From: Paul Cann
Sent: 30 June 2017 14:06
To: Planning.Responses
Cc: Anita Gardner; Tracey Headley-Smith; Wendy Ashenden-Bax
Subject: RE: Planning Consultation on: EP/88/17/DOC

APPLICATION NO: EP/88/17/DOC

Site Address: Bradbury Hotel Station Road East Preston BN16 3FF

Description of Works: Application for approval of matters reserved by condition imposed under EP/63/16/PL relating to conditions 9 for surface water drainage & 10 for SUDs information.

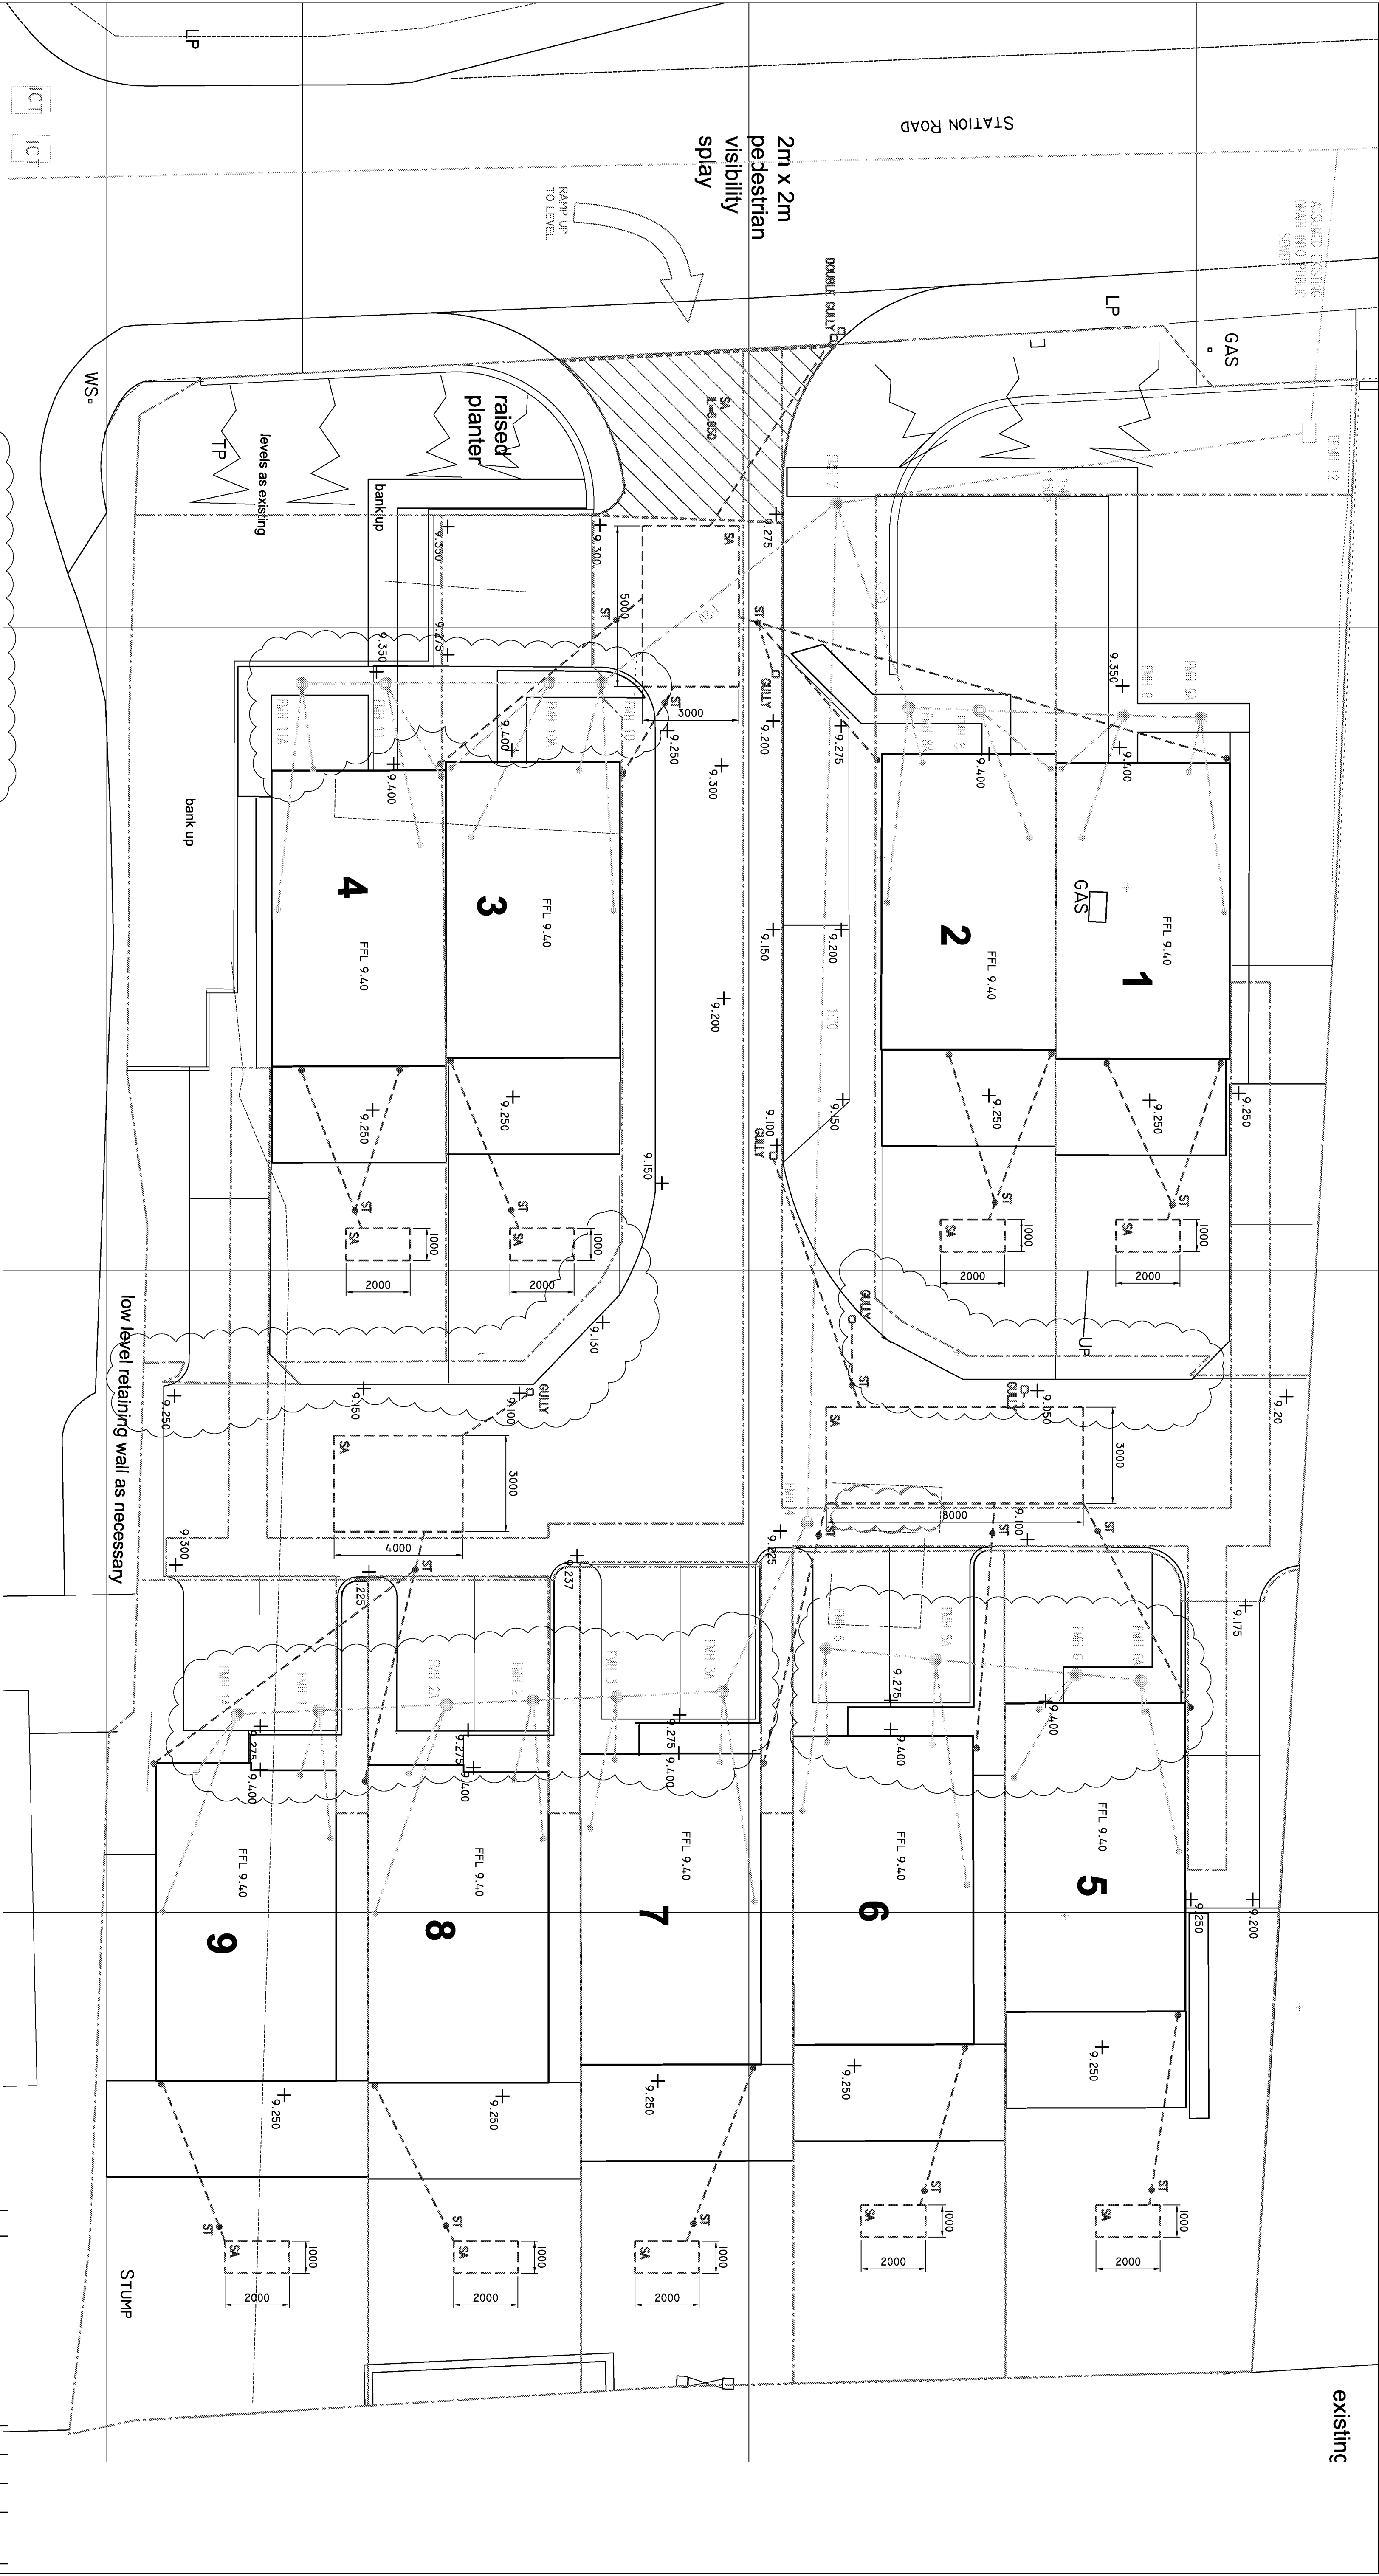
3. Microdrainage calculations – The structures modelled (apart from the 2 x 1m plan area soakaways) do not correspond to the soakaways detailed on drawing WO1371-200 Rev C01, in terms of plan area. The calculations need to be resubmitted accordingly for each different soakaway plan area. This drawing needs to specify the invert levels of the pipe entries into each soakaway, soakaway base and cover levels, top of crate levels. The levels used in the calculations also need to correspond to the relative levels used on the drawing, as currently they do not.
4. Please provide construction detail for the silt trap manholes.
